**TRANSITIONAL PART 3A PROJECT
ASSESSMENT**

**Section 75W Modification Request
DEXUS Industrial Estate, Greystanes
Southern Employment Lands, Holroyd
Local Government Area
(MP08_0259 MOD 5)**

Director-General's
Environmental Assessment Report
Section 75W of the
Environmental Planning and Assessment Act 1979

May 2013

Landscape Concept Documentation-
Roche Facility: 20 Reconciliation Drive, Greystanes, NSW

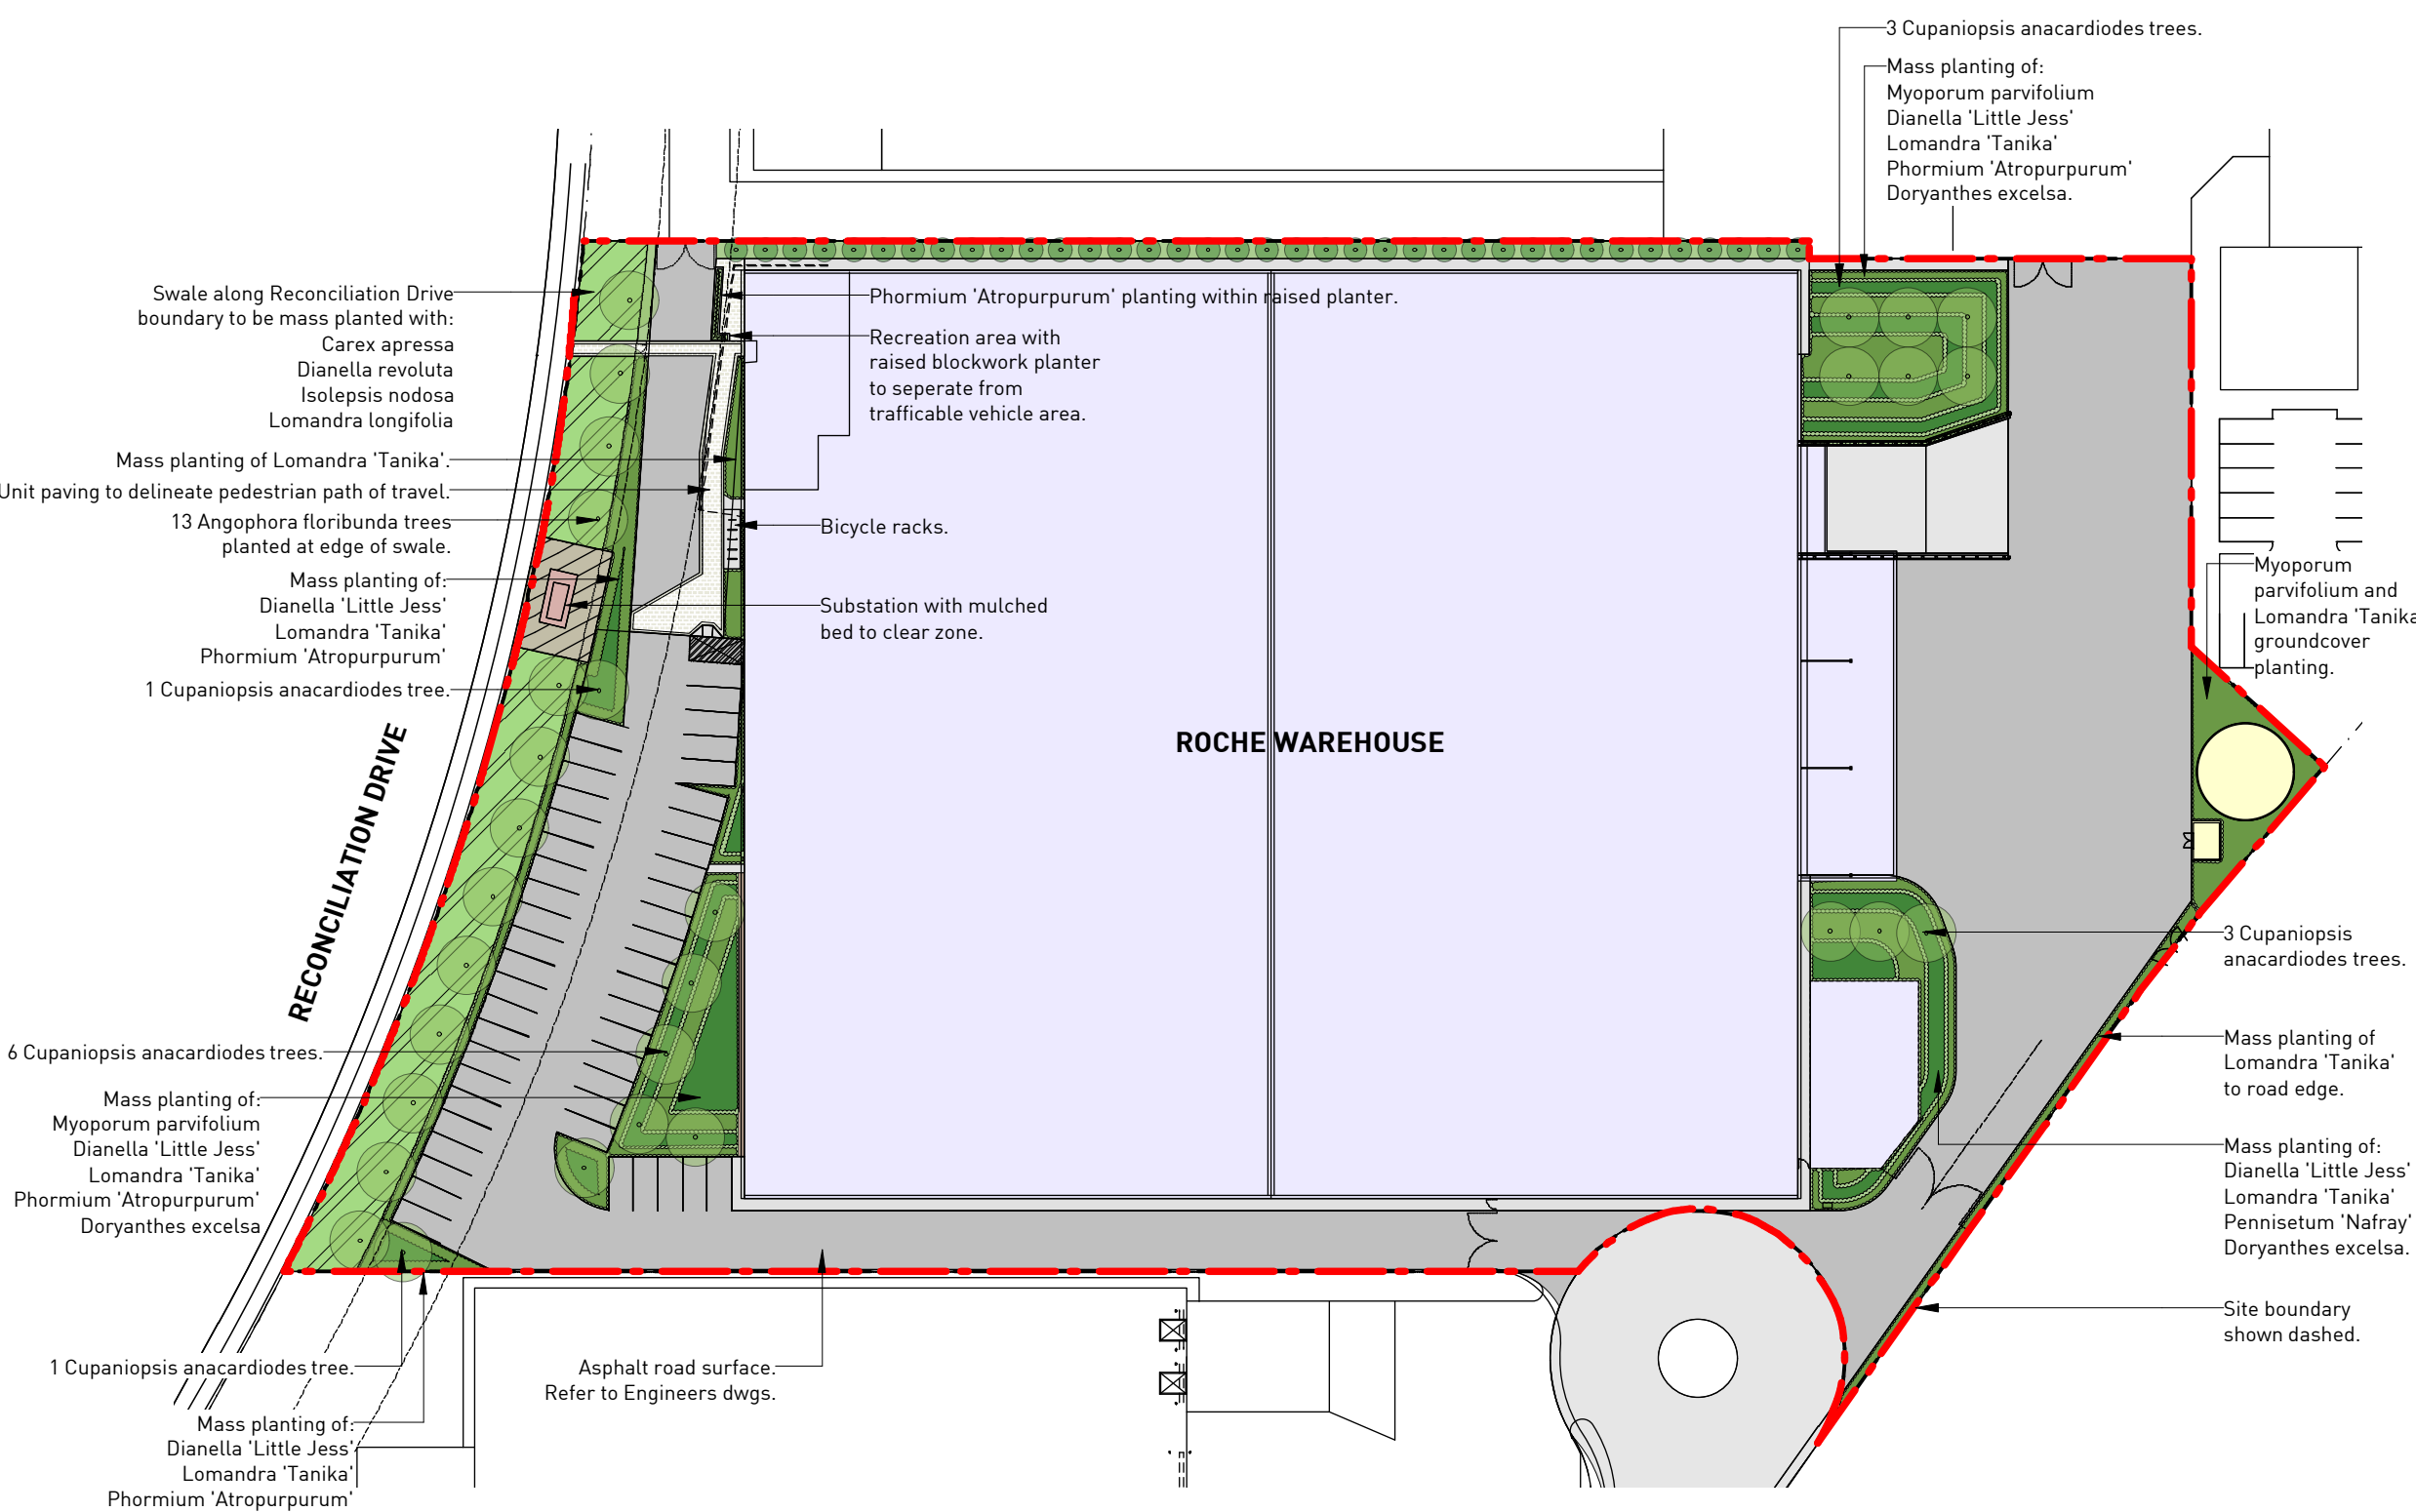
6. Landscape plan to be prepared by qualified landscape architect.	The landscape plan has been prepared by qualified landscape architects Habitation.
7. CPW species to be consistent with landscape masterplan for estate	The Landscape Plan has been amended to incorporate additional CPW tree species, in a manner that is consistent with the estate Landscape Masterplan. The revised Landscape Plan is attached in Appendix E of EA .

drawing title
Swept Paths - Recessed Loading Dock 1

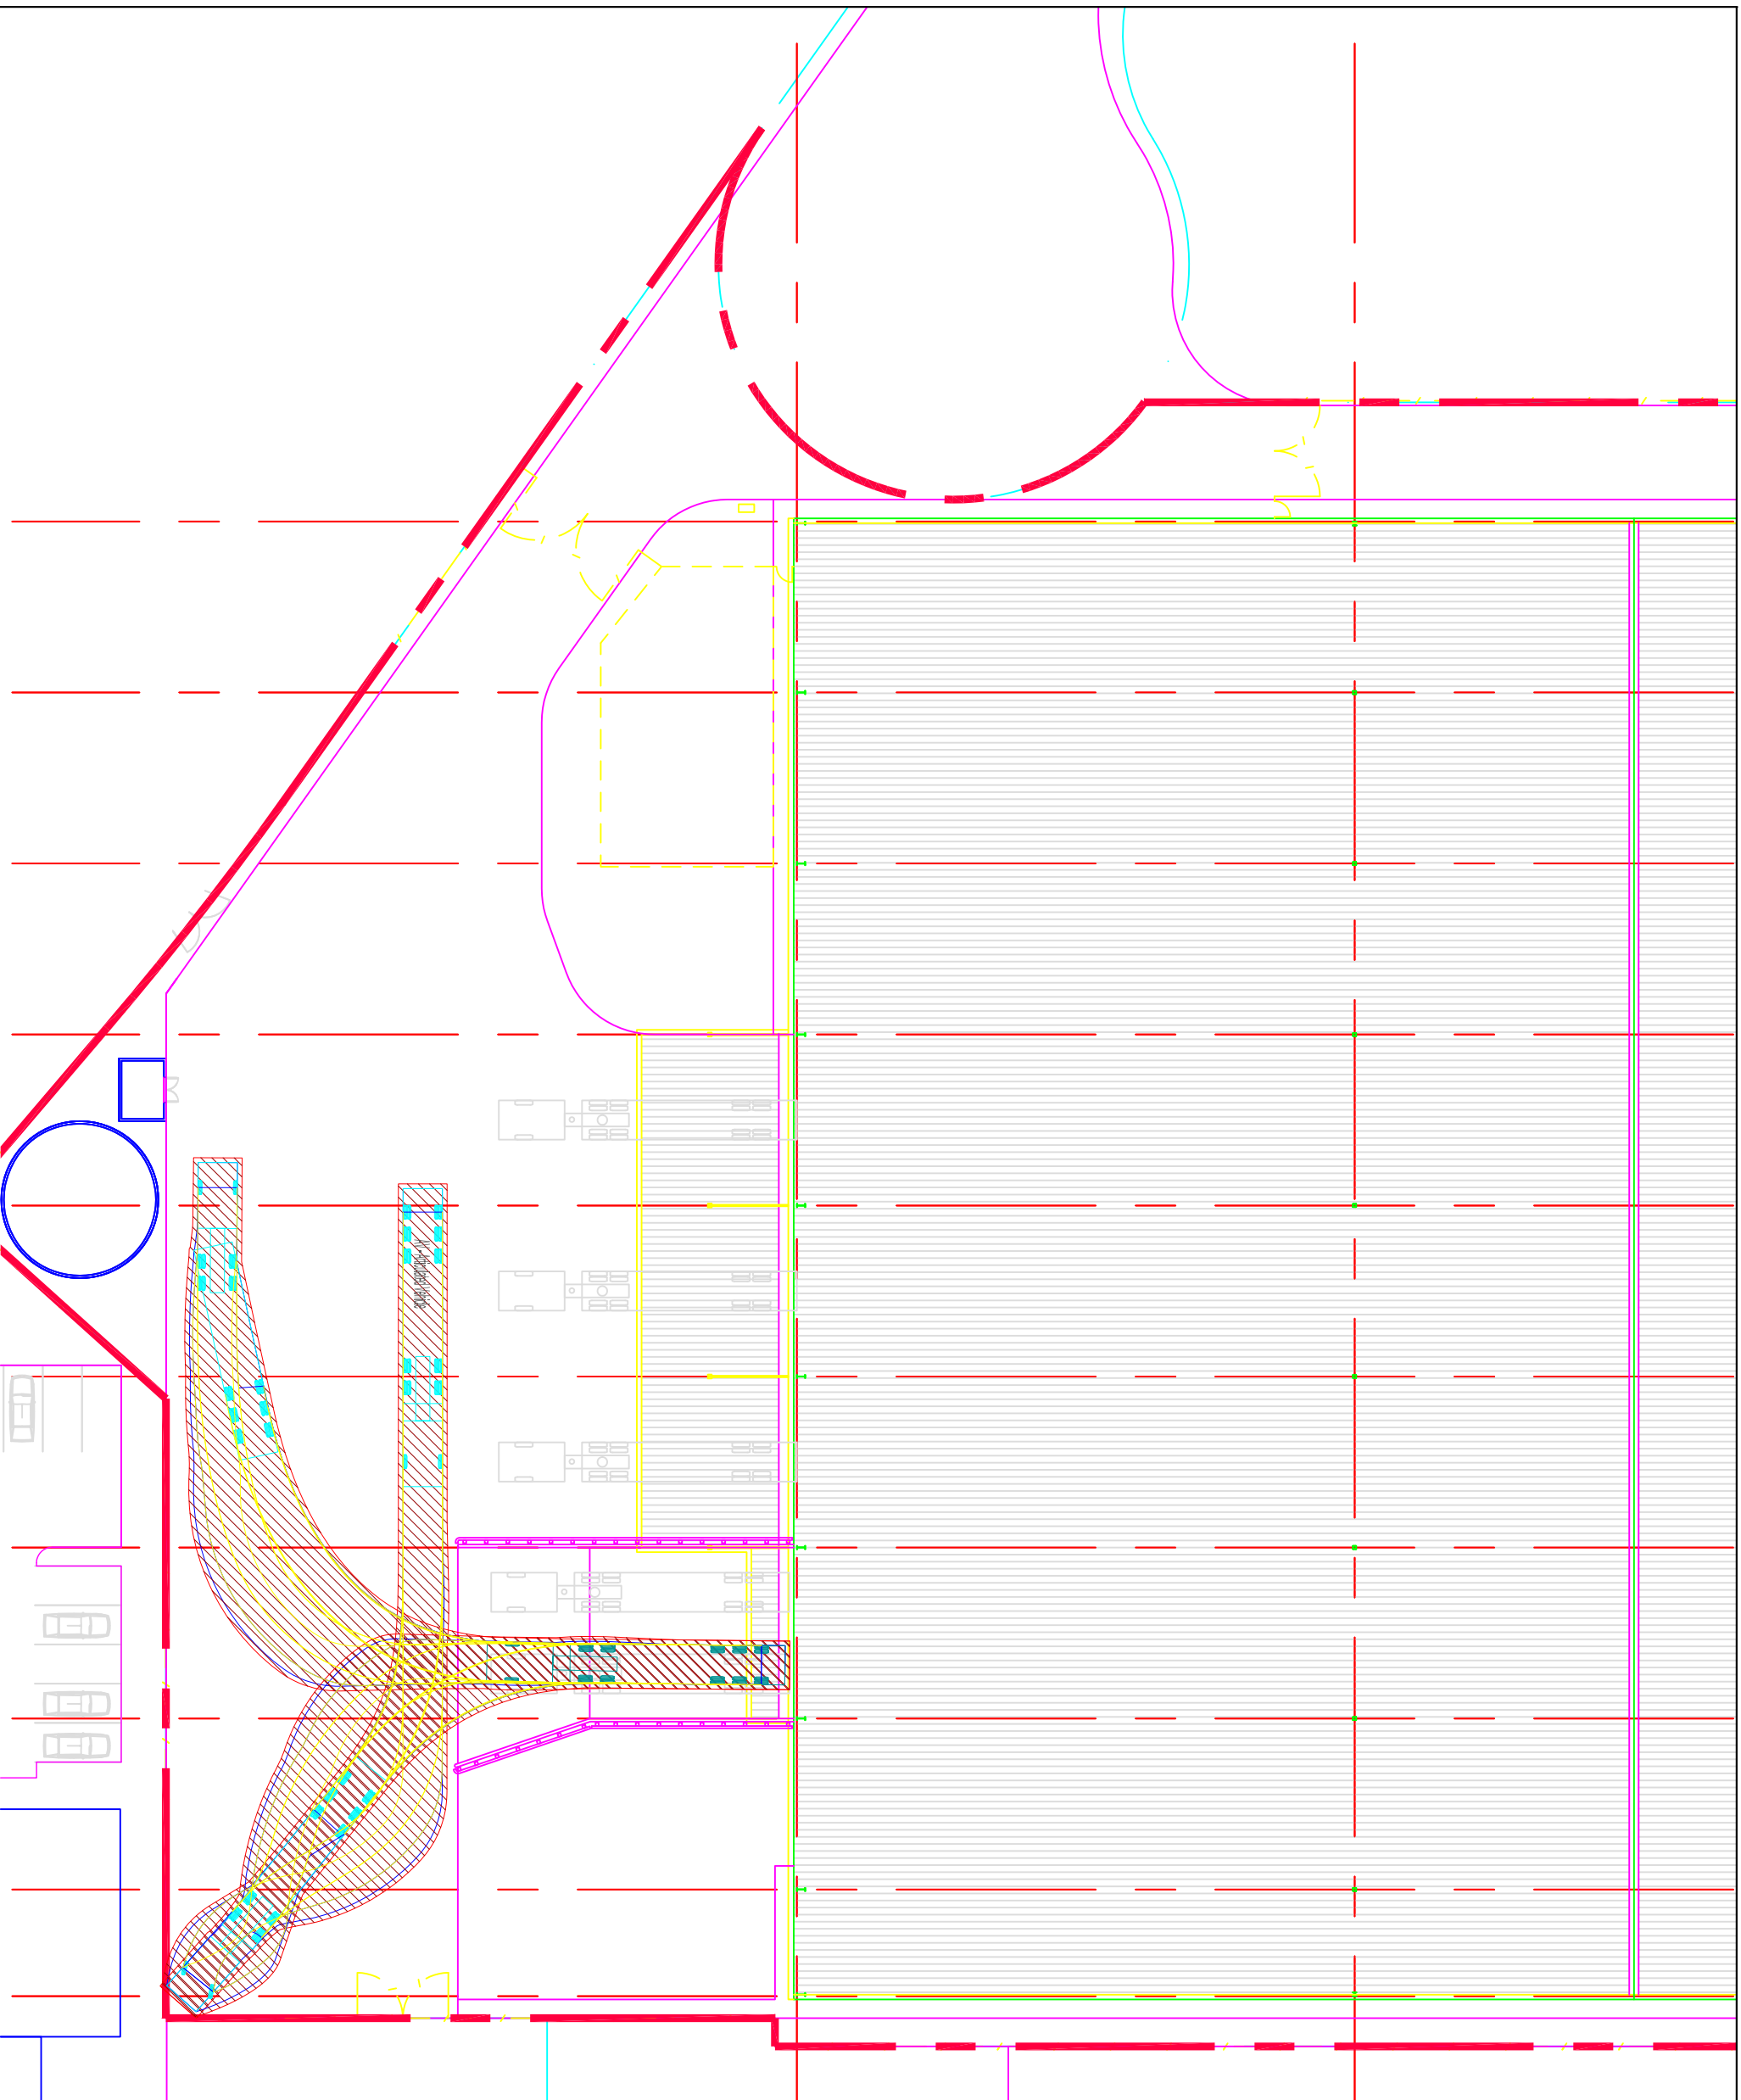
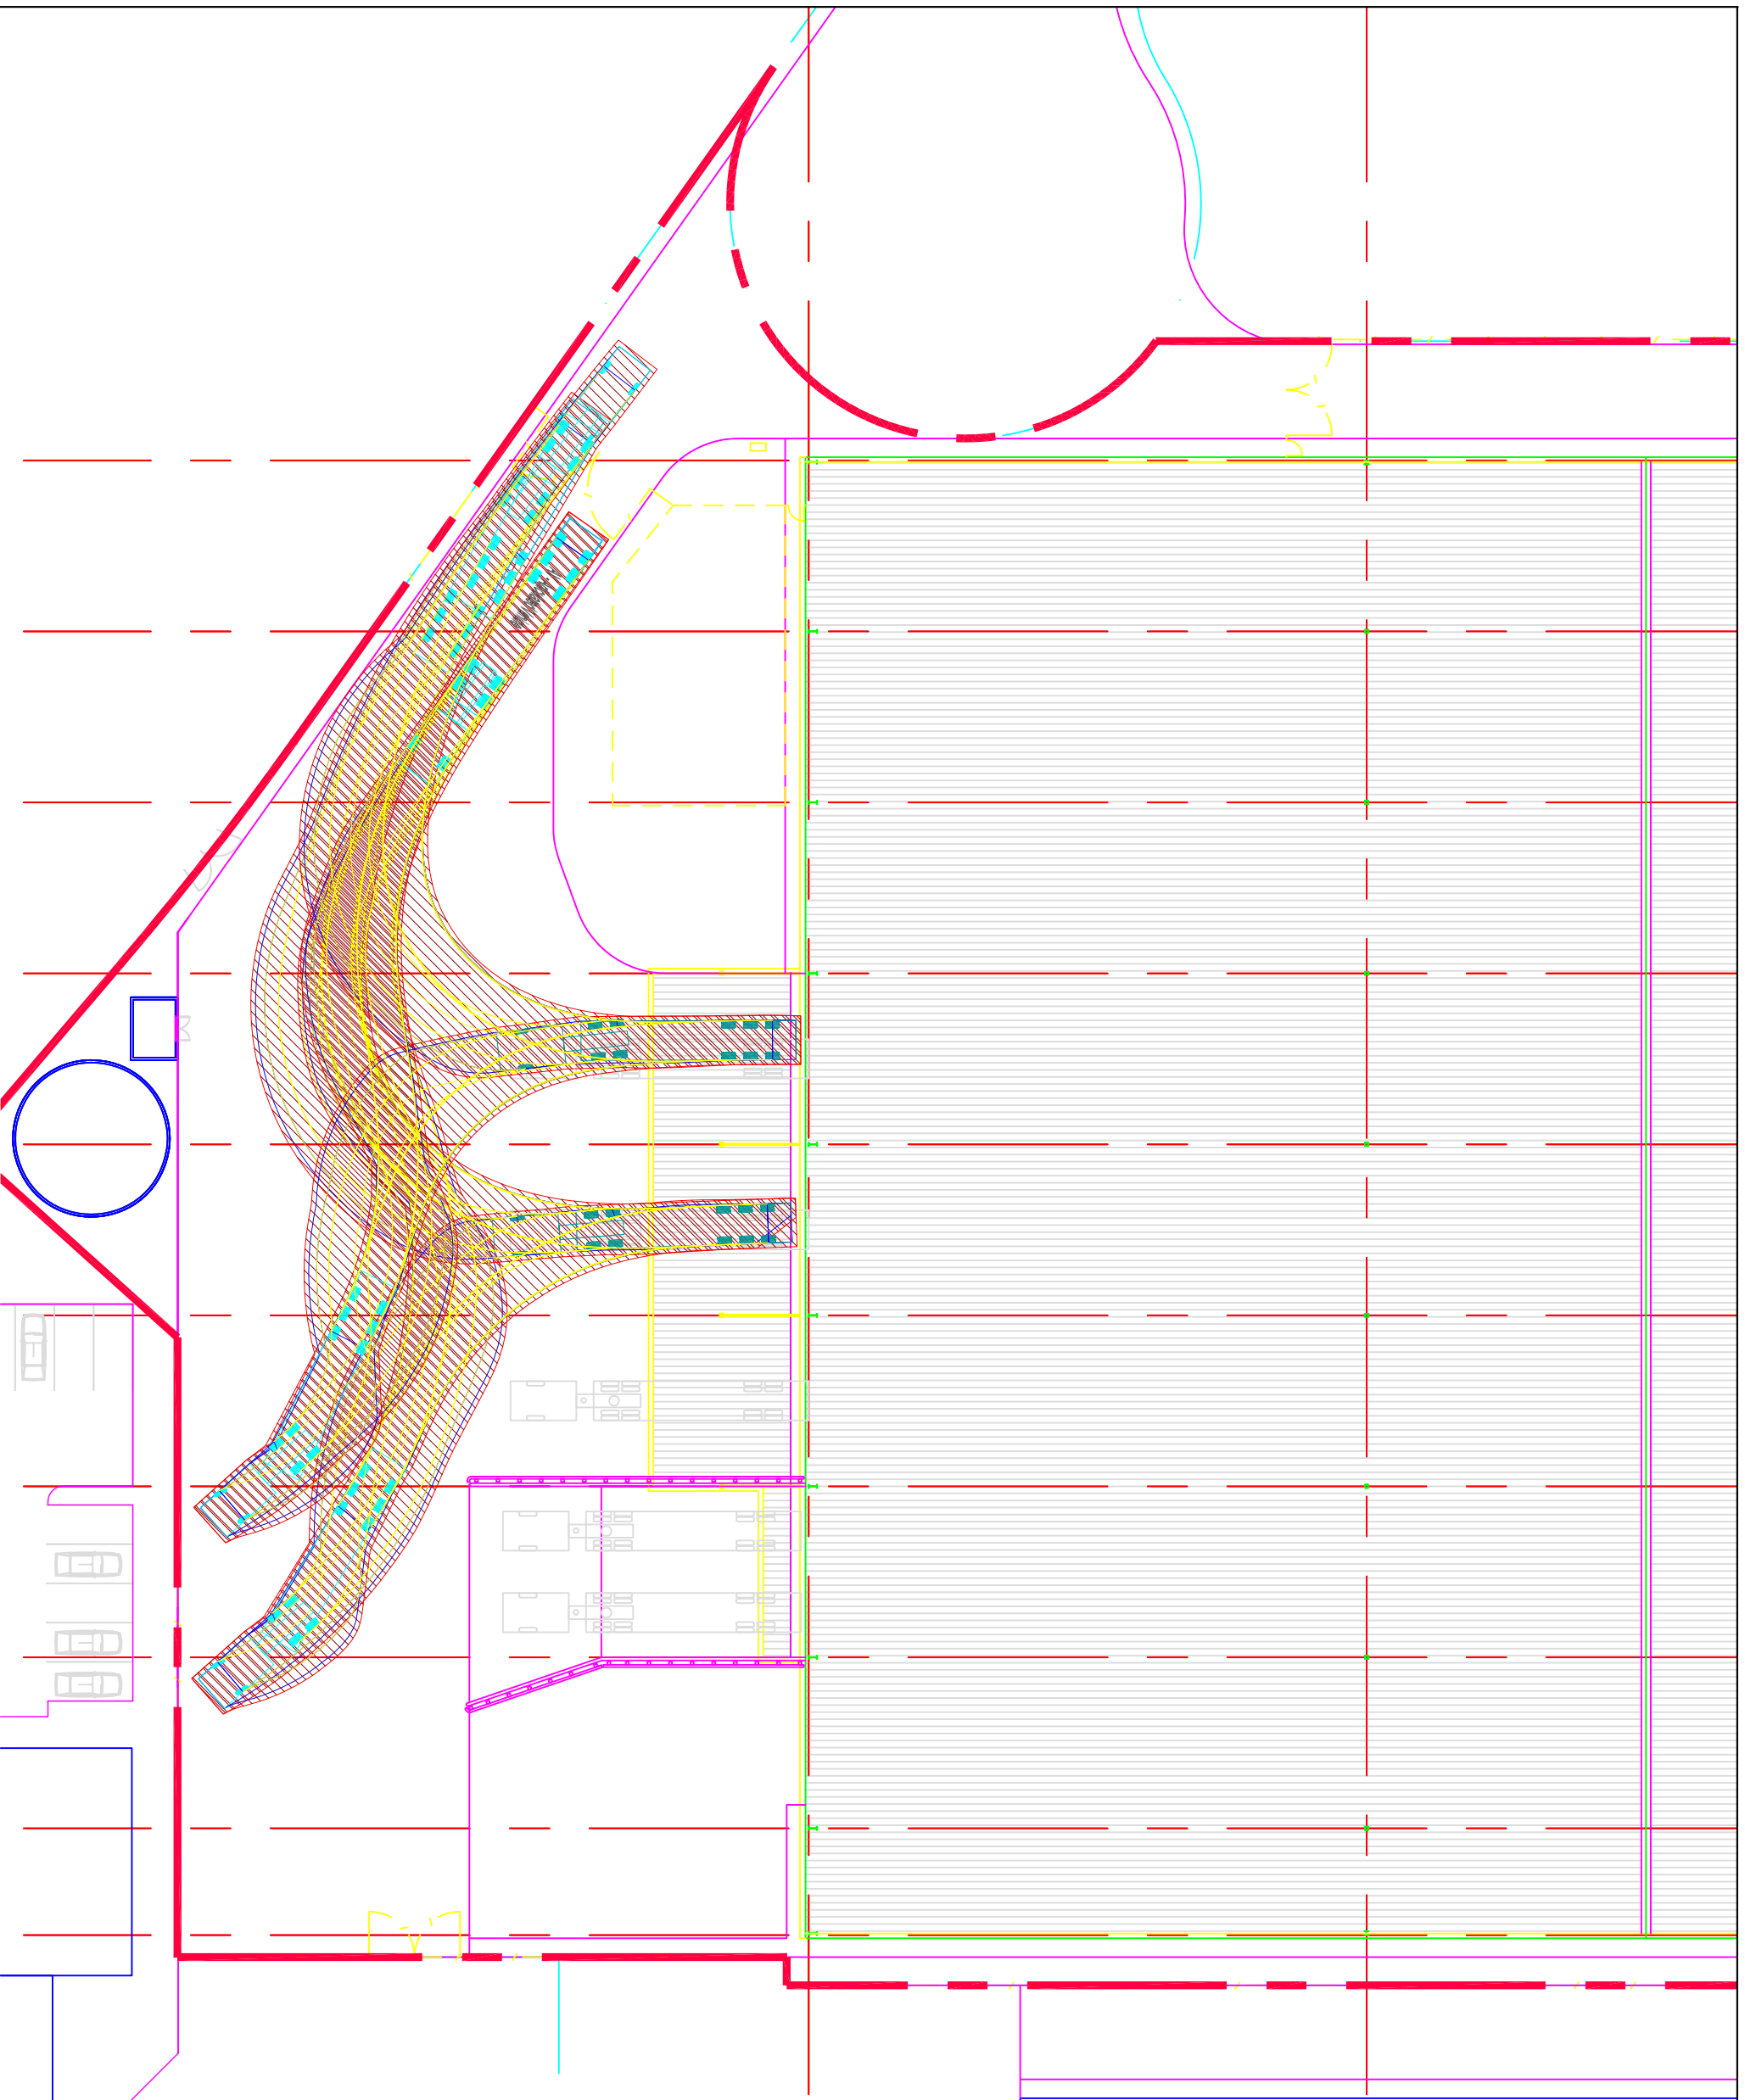
21. Swept paths	Swept paths are provided on the plans for the largest vehicle proposed to access the site (ie. 19 metre articulated, with adequate capacity for b-doubles to enter and exit in a forward direction).
